CITY OF ALBUQUERQUE

September 30, 2014

Re: Capstone Student Housing Zone 4
Transport Ave SE
Request Permanent C.O. - Accepted
Engineer's Stamp dated: 12-13-13 (M15D026)
Certification dated: 9-29-14

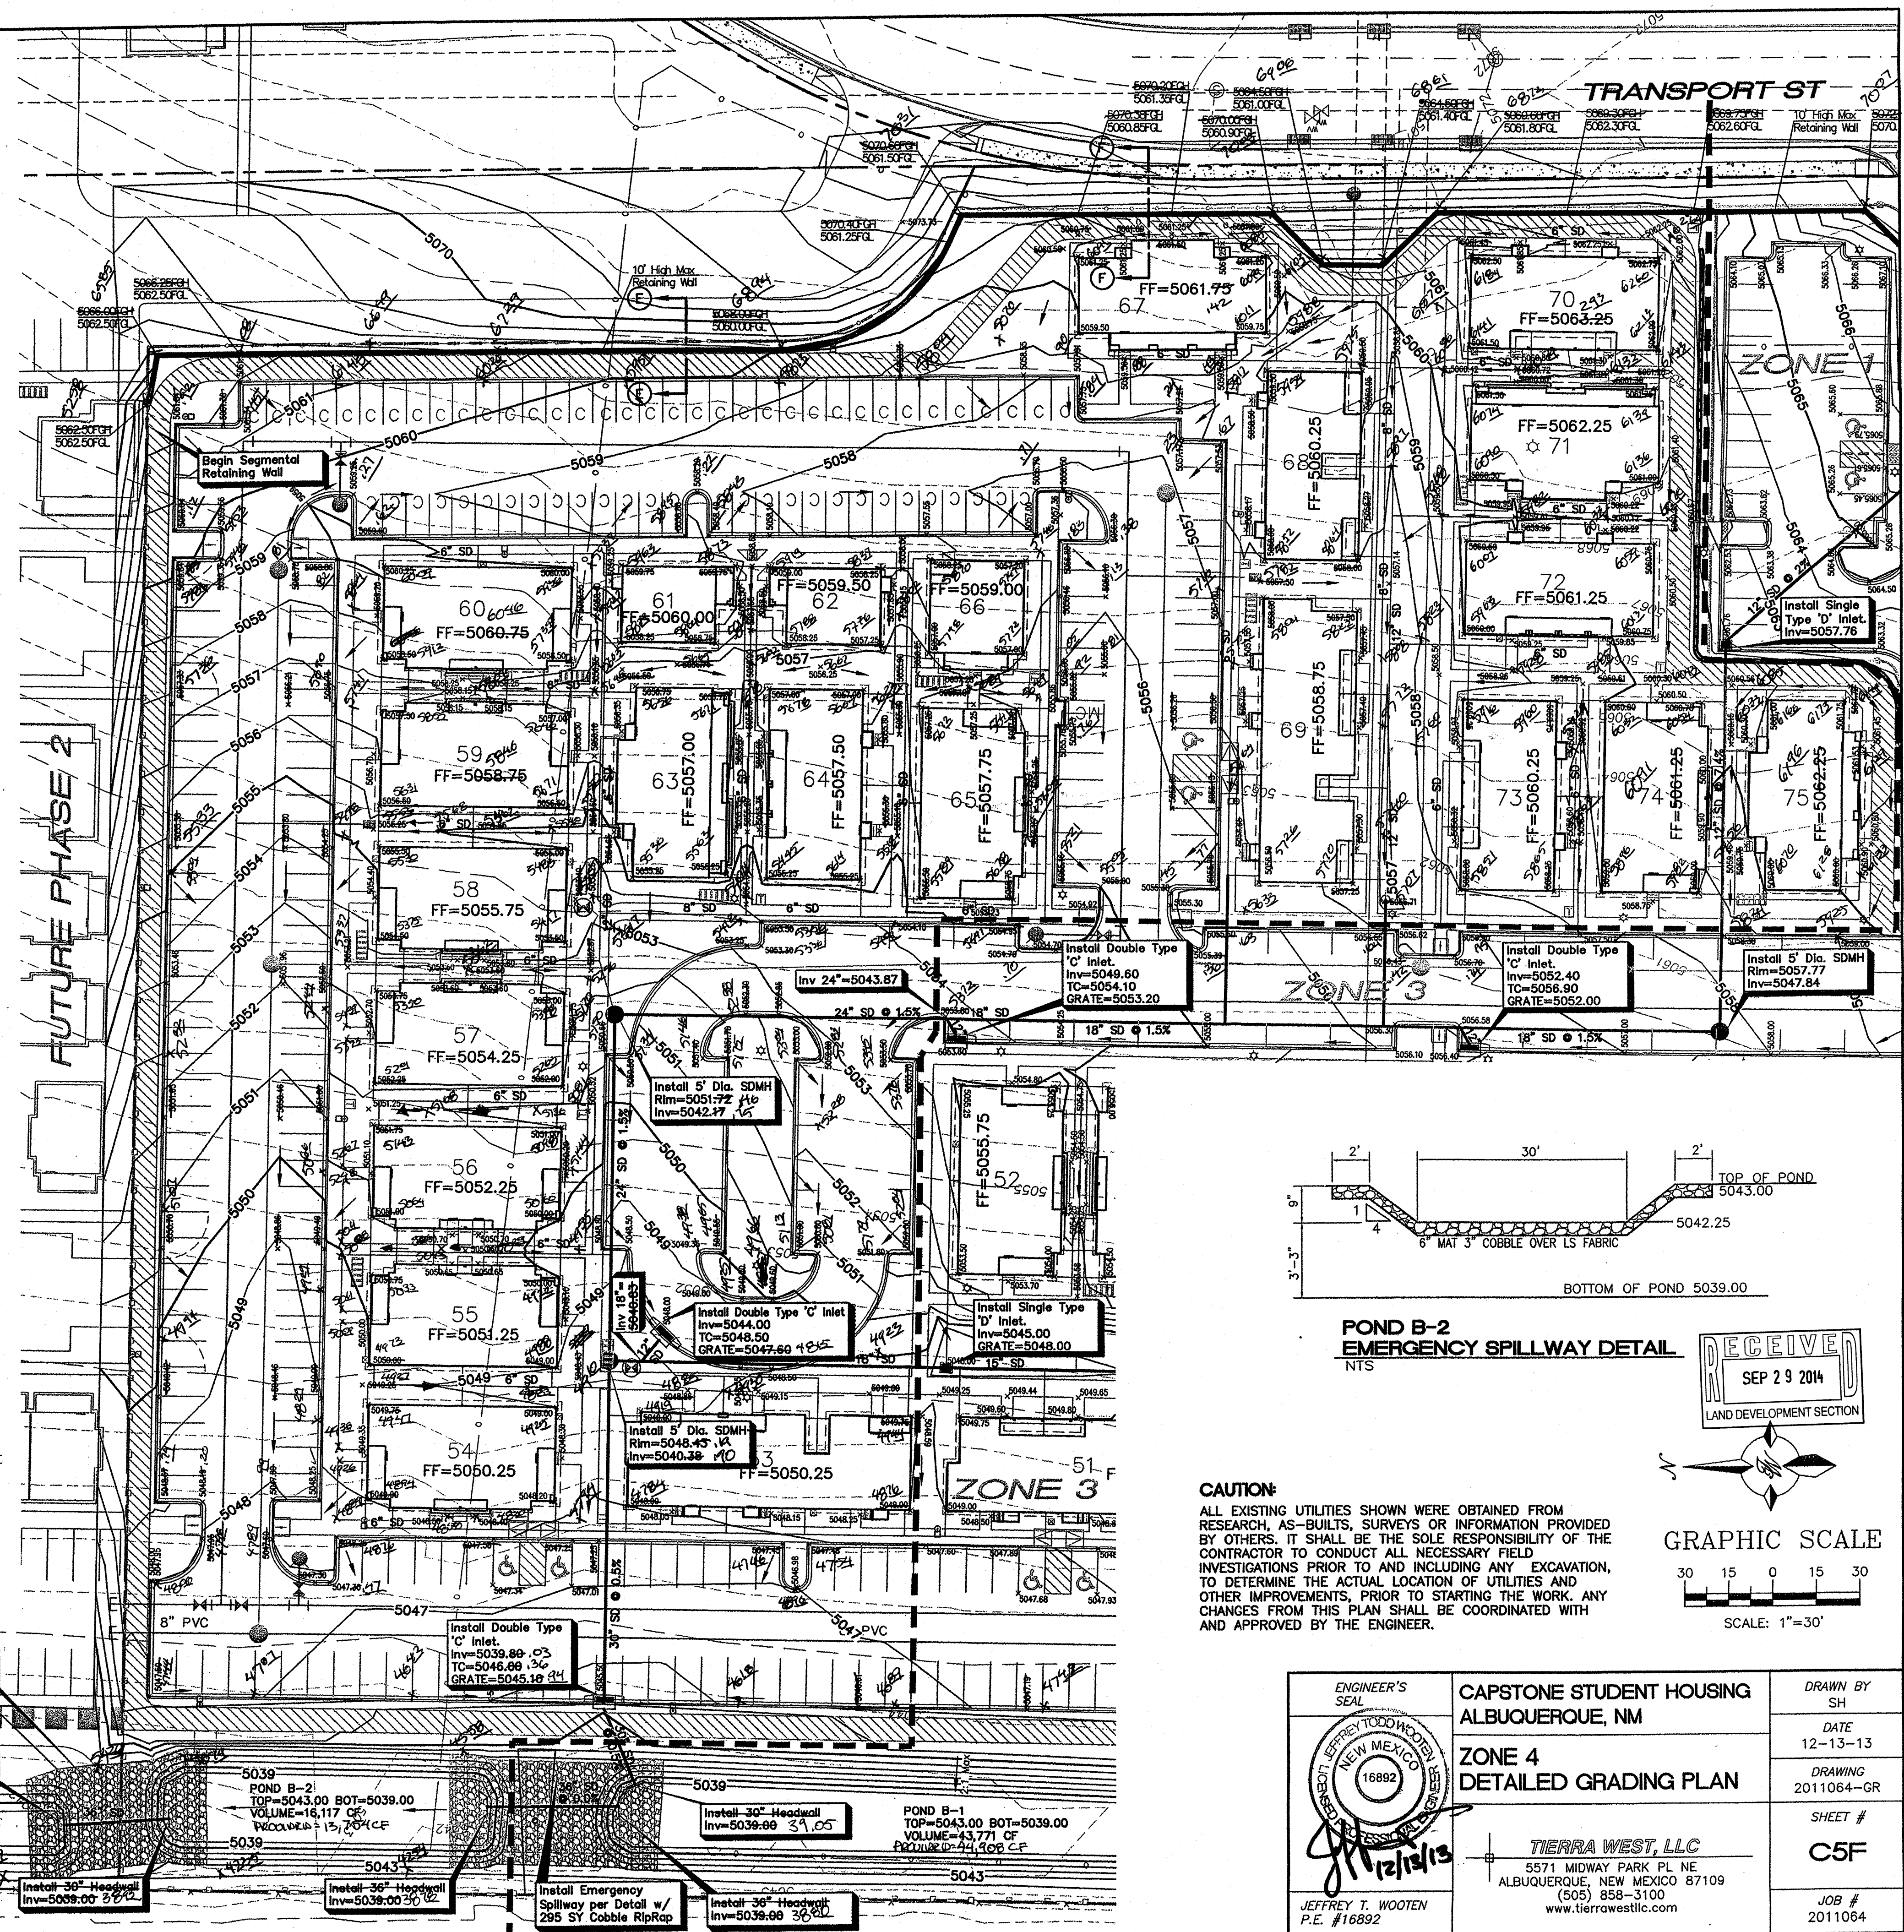
- 30" headerwall should be change to 36" headerwall for the 36" storm drain pipe connecting Pond B-2 to Pond B-3.
- When providing as-built drawings, please provide all inlet numbers, inlet/mh/storm drain pipe inverts, inlet top of curb and grate elevations, and all the storm drain pipes slopes and normal flow depths.
- As-built pond volumes should be provided.

**ZONE 4  
DETAILED GRADING PLAN**

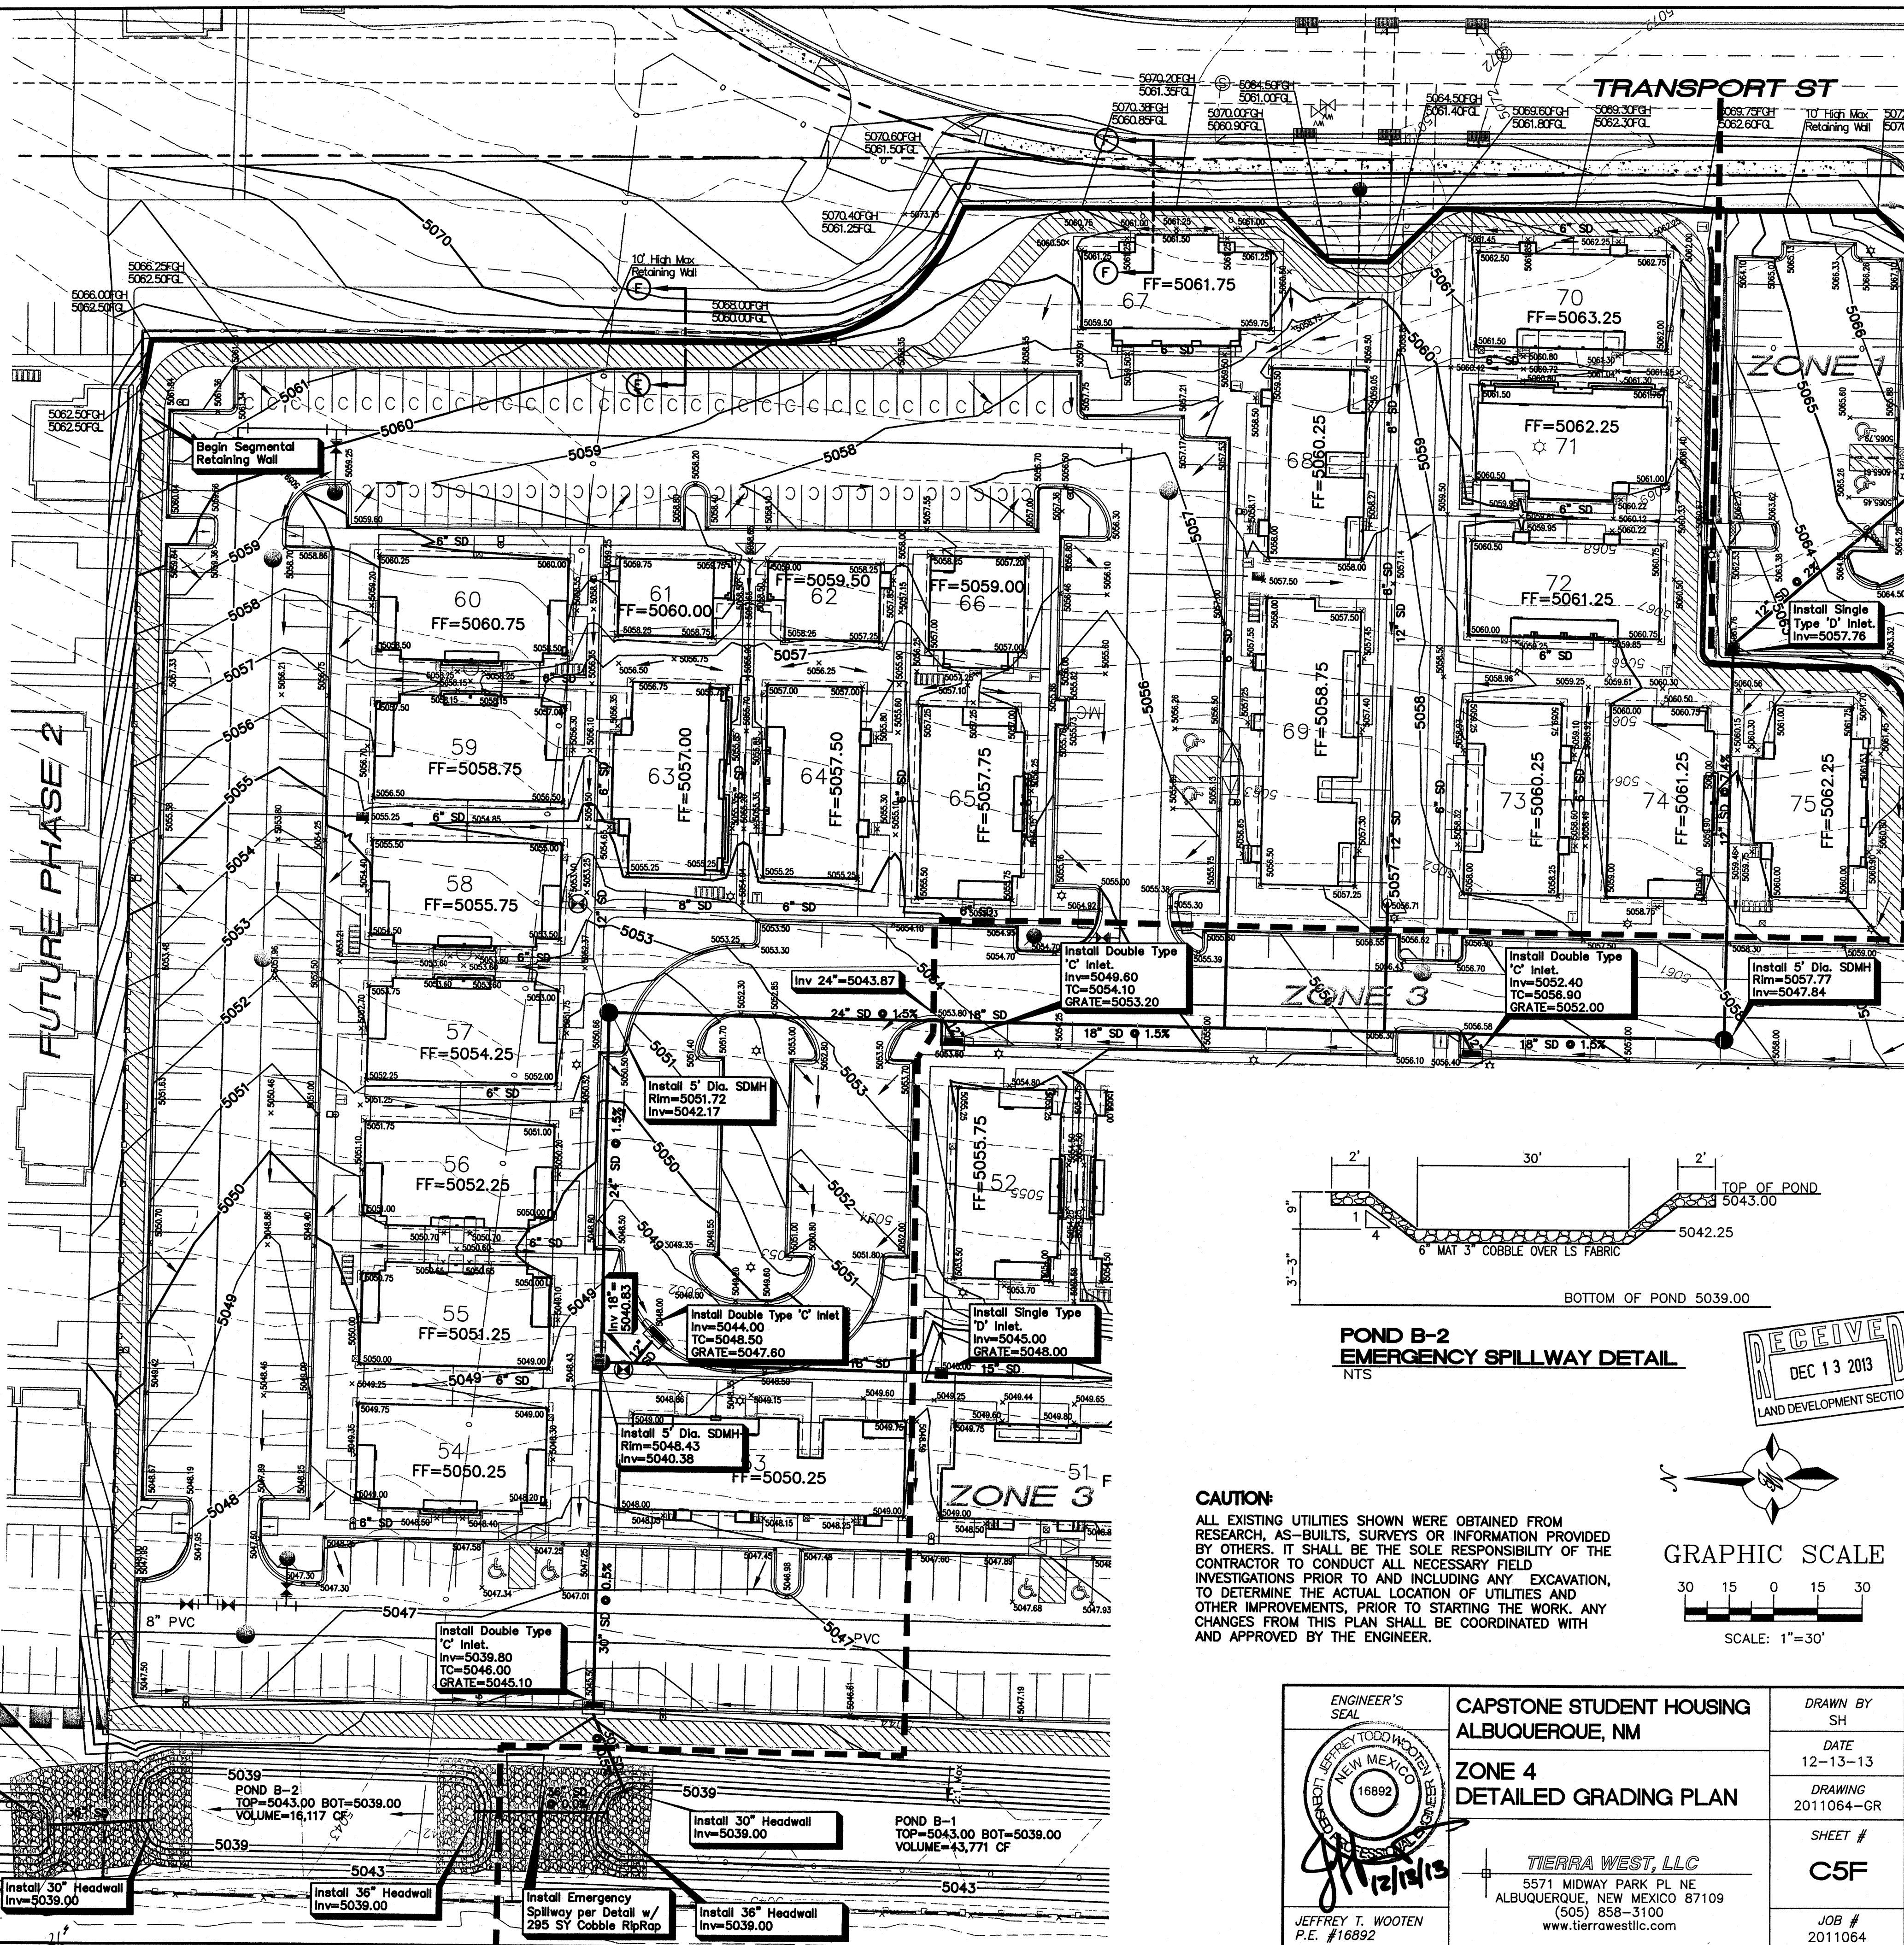
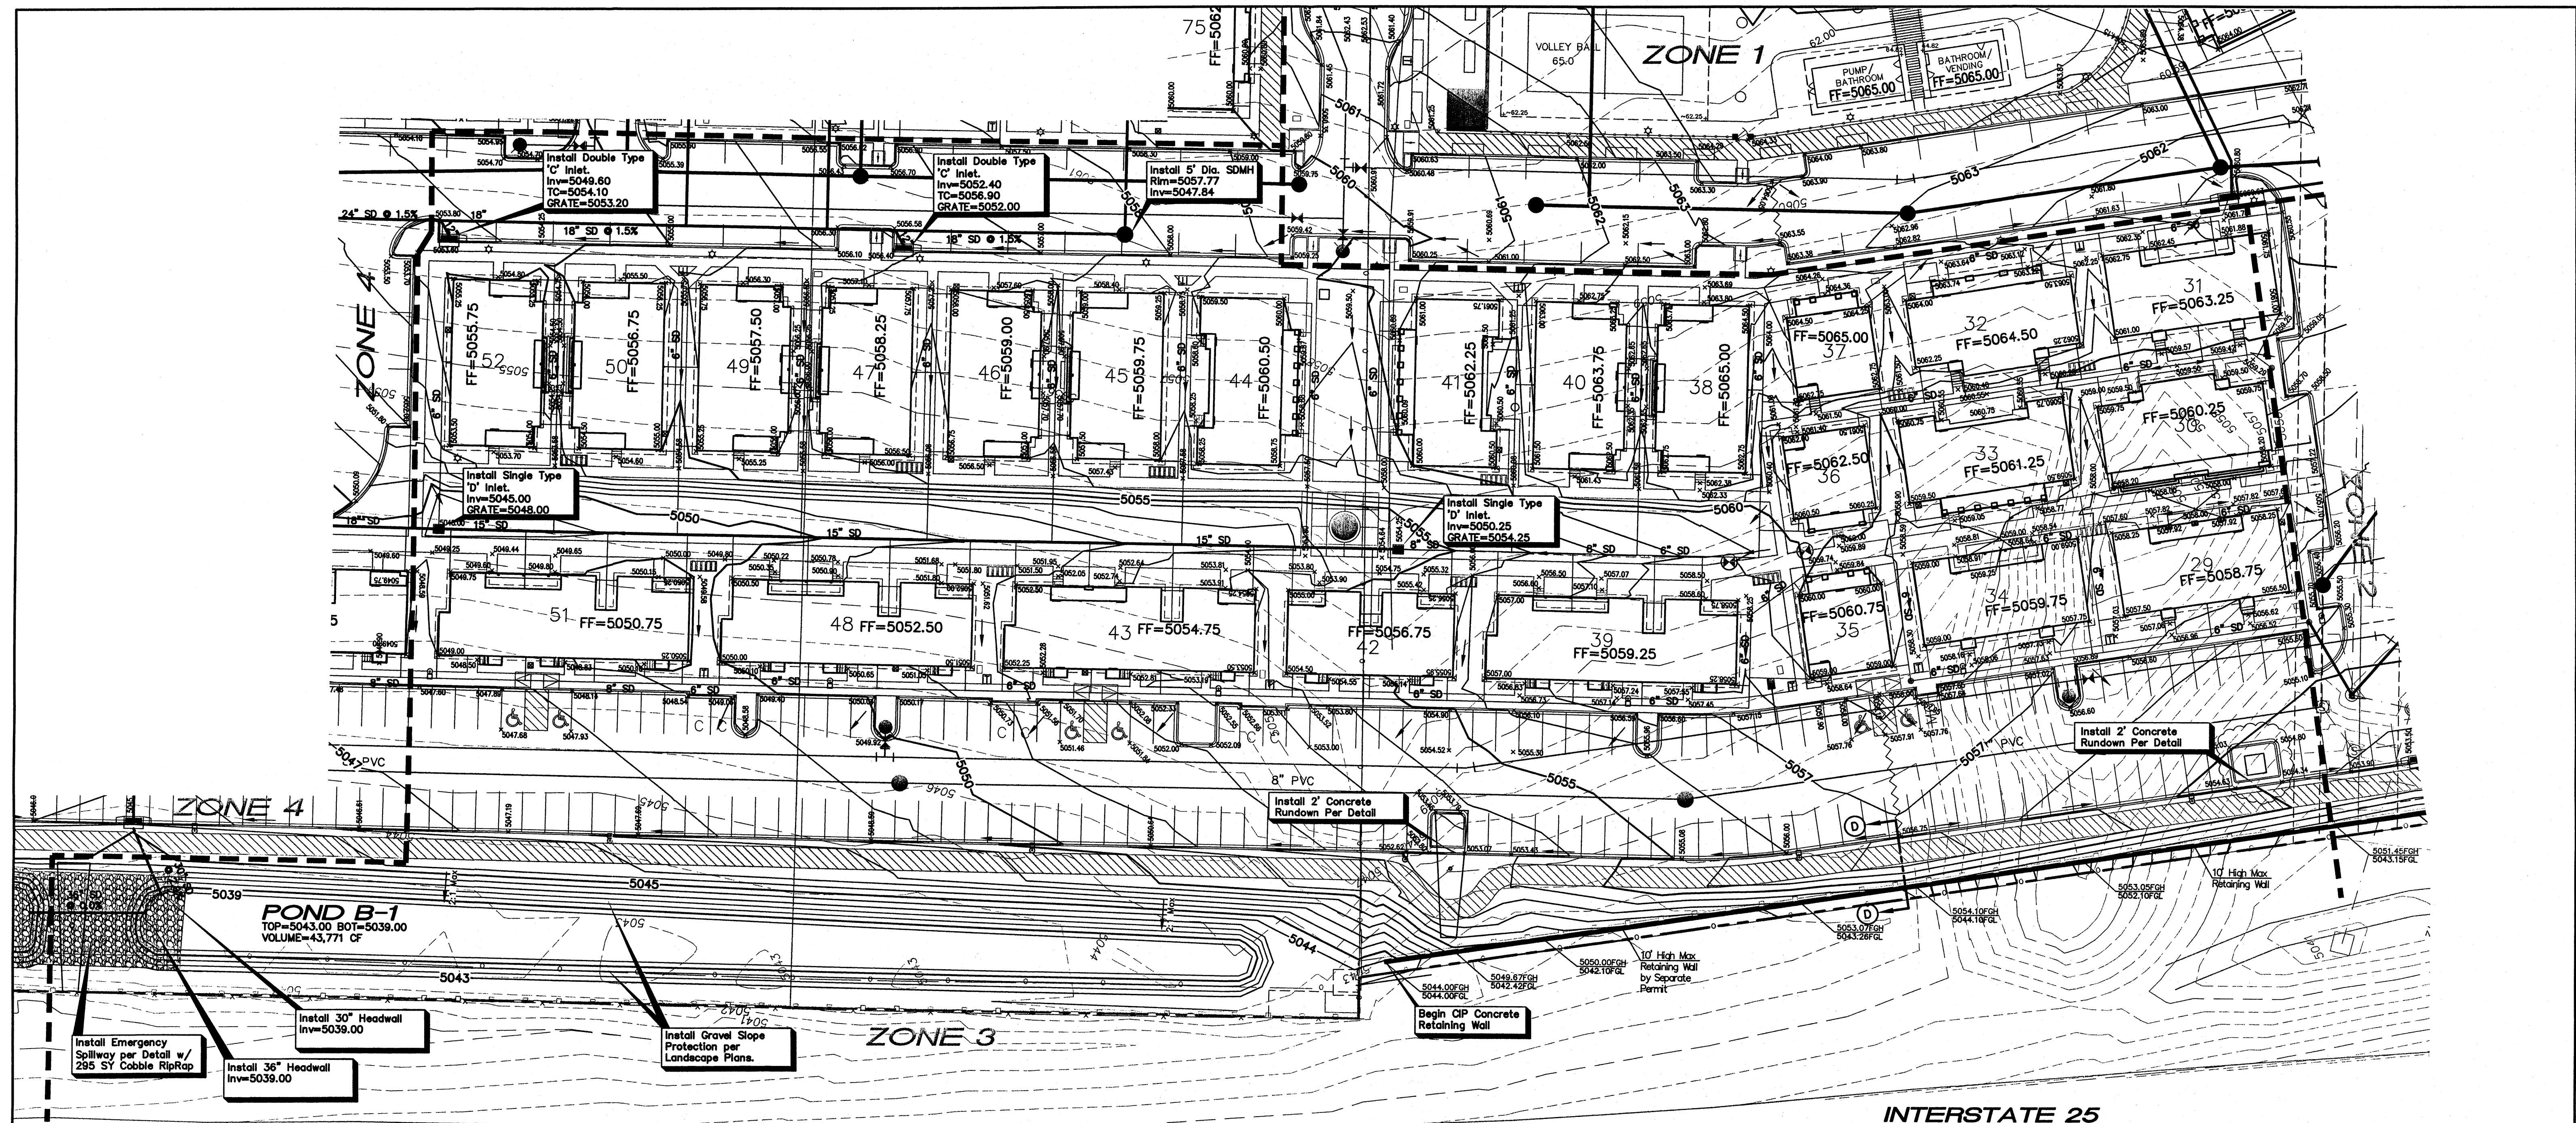
1. The manhole connections to the public storm drain must be confirmed to be acceptable.
2. As-built grades are required per the DPM.
3. How does Pond B-2 function as designed when it was built at 85% of its design capacity? It seems the grading should be revised.
4. Install the trash screen at the outlet to Pond B-3.
